**Consultation Response from KC,  
Lead Local Flood Authority**

**2023/91116 Land off, Primrose Lane, Hightown, Liversedge, WF15**

**Erection of 67 dwellings**

**Date Responded: 01/06/2023.**

DRAINAGE STRATEGY

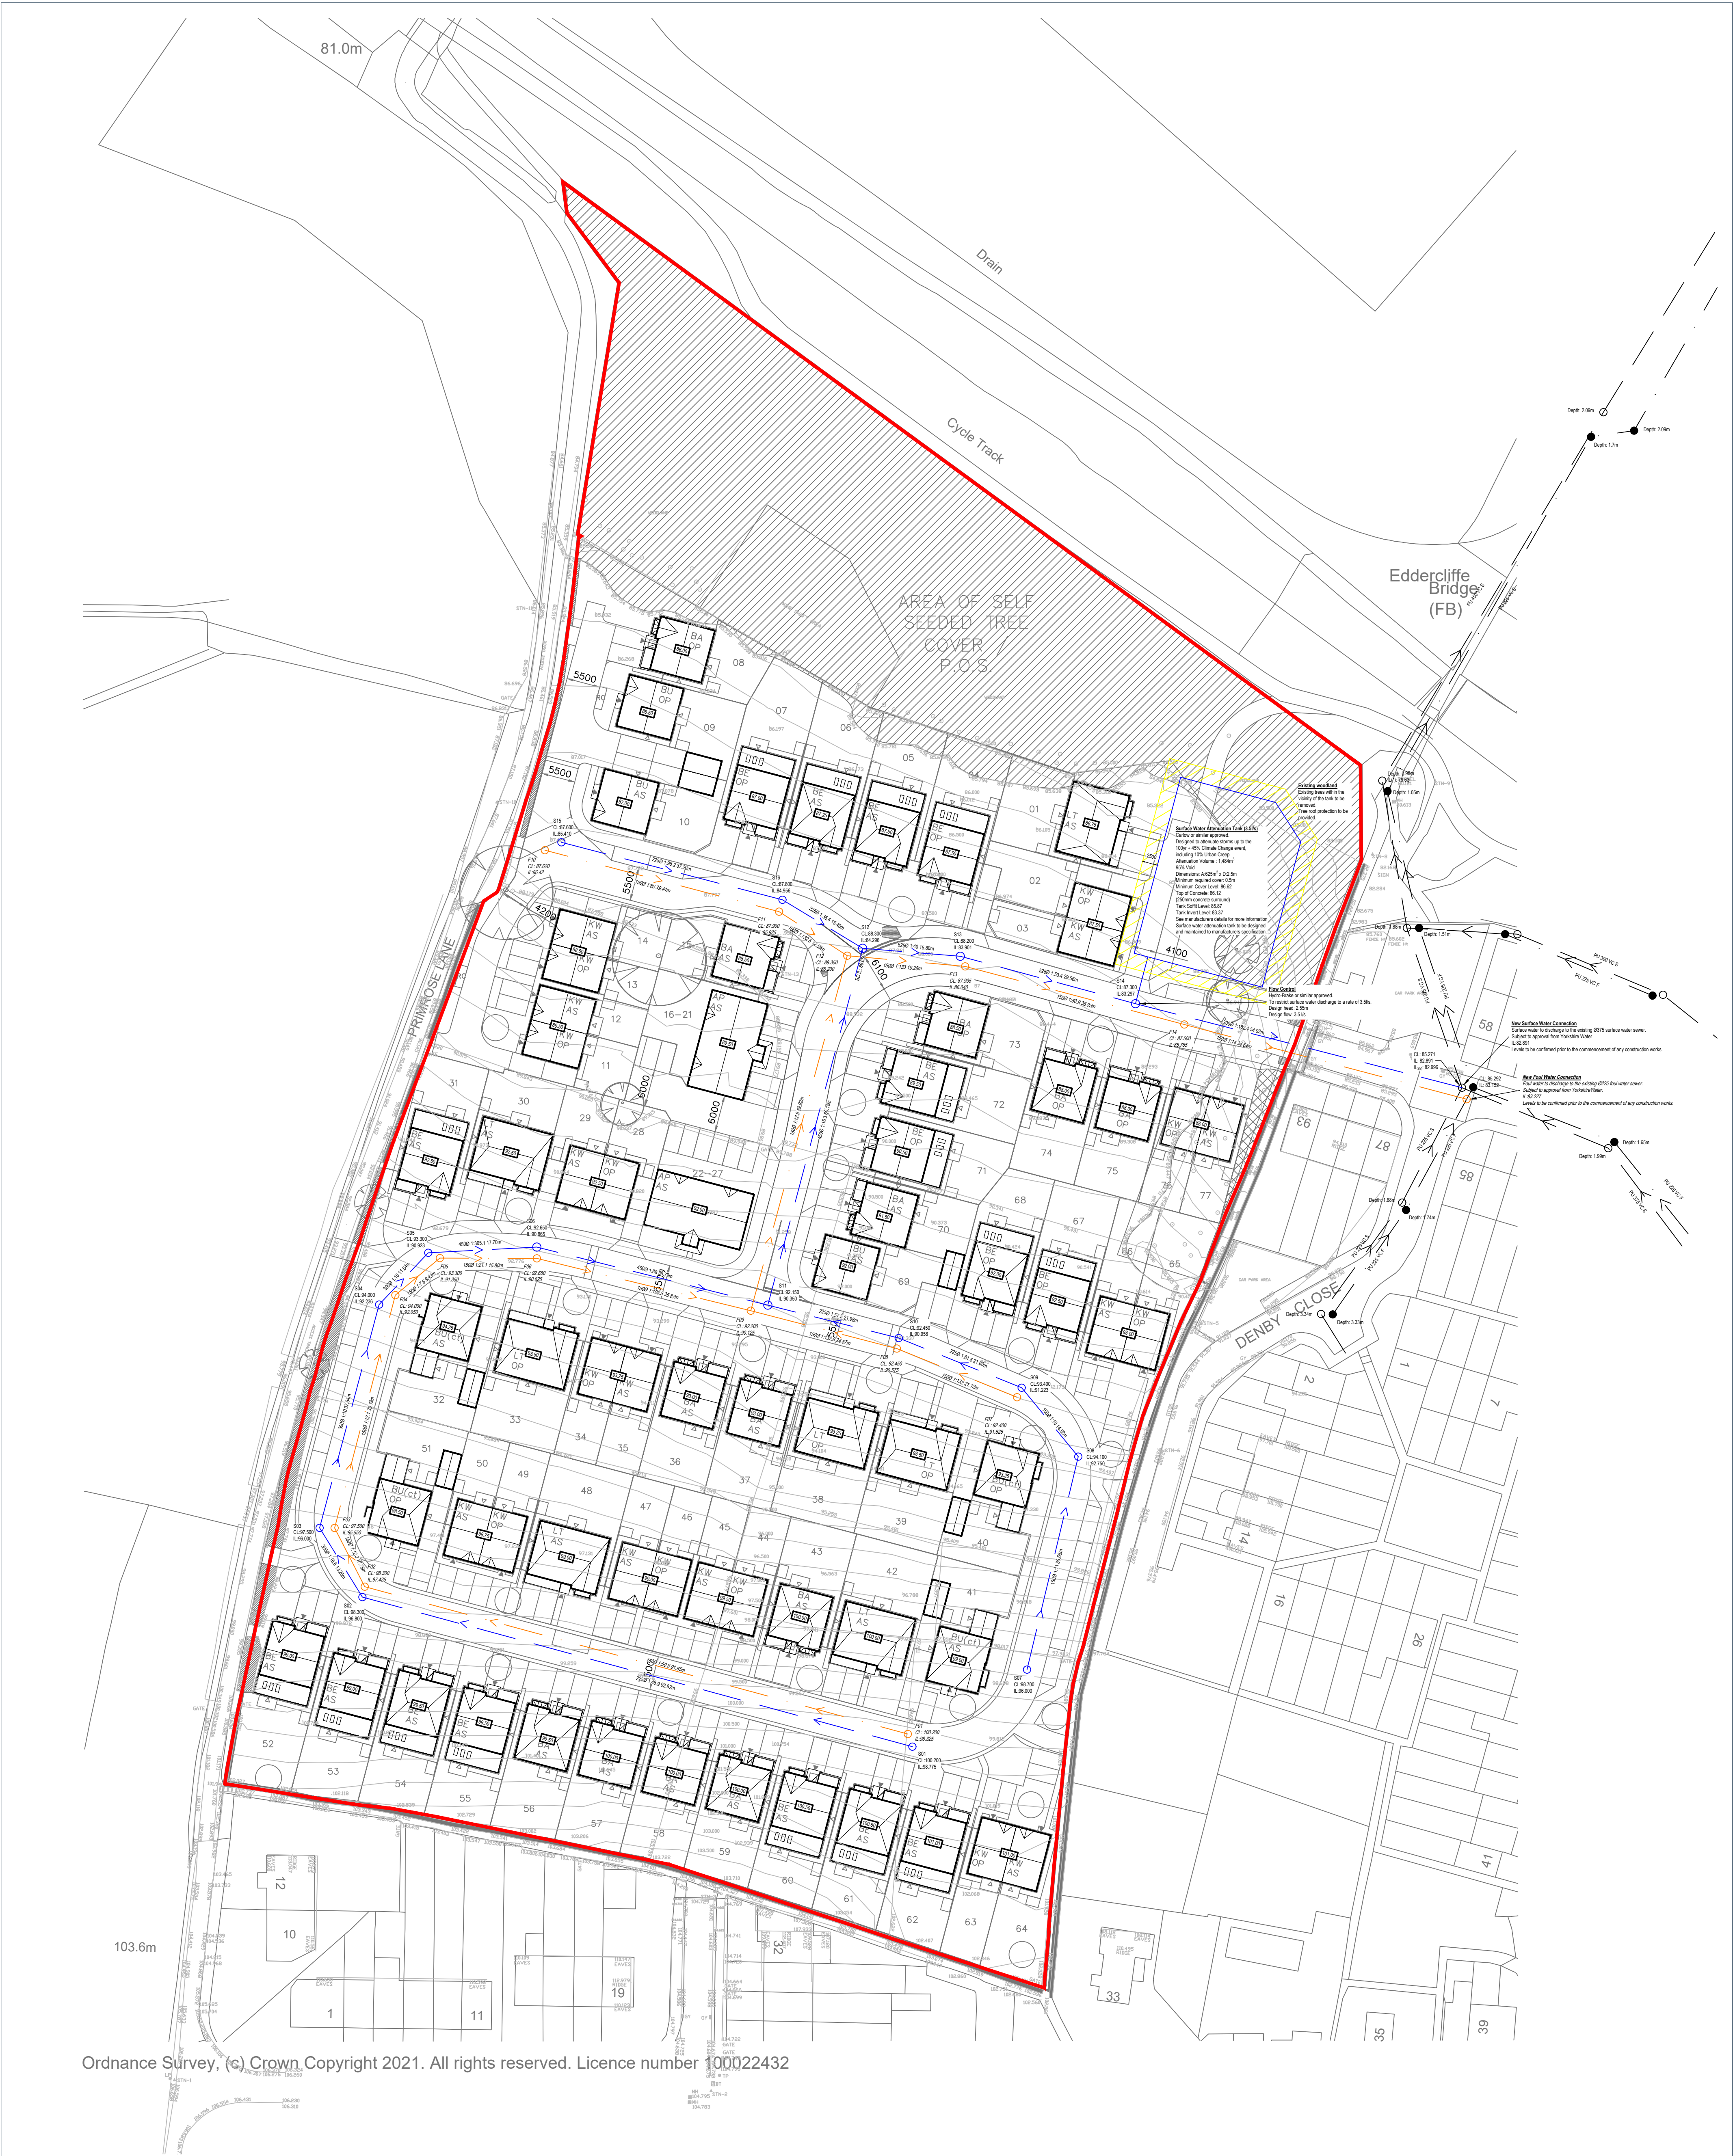
The watercourse option would be the most favoured by the LLFA, however a CCTV survey of the culvert would need to be undertaken to confirm the condition and capacity of the pipe. The survey results should be provided to the LLFA for comment/acceptance.

The proposed allowable discharge rate of **6.6 l/s** for the surface water outfall is accepted by the LLFA (subject to a minimum flow control outlet diameter of 75mm)

The LLFA has no further concerns regarding the surface water drainage proposal as set out in the FRA and the associate Drainage Strategy drawings.
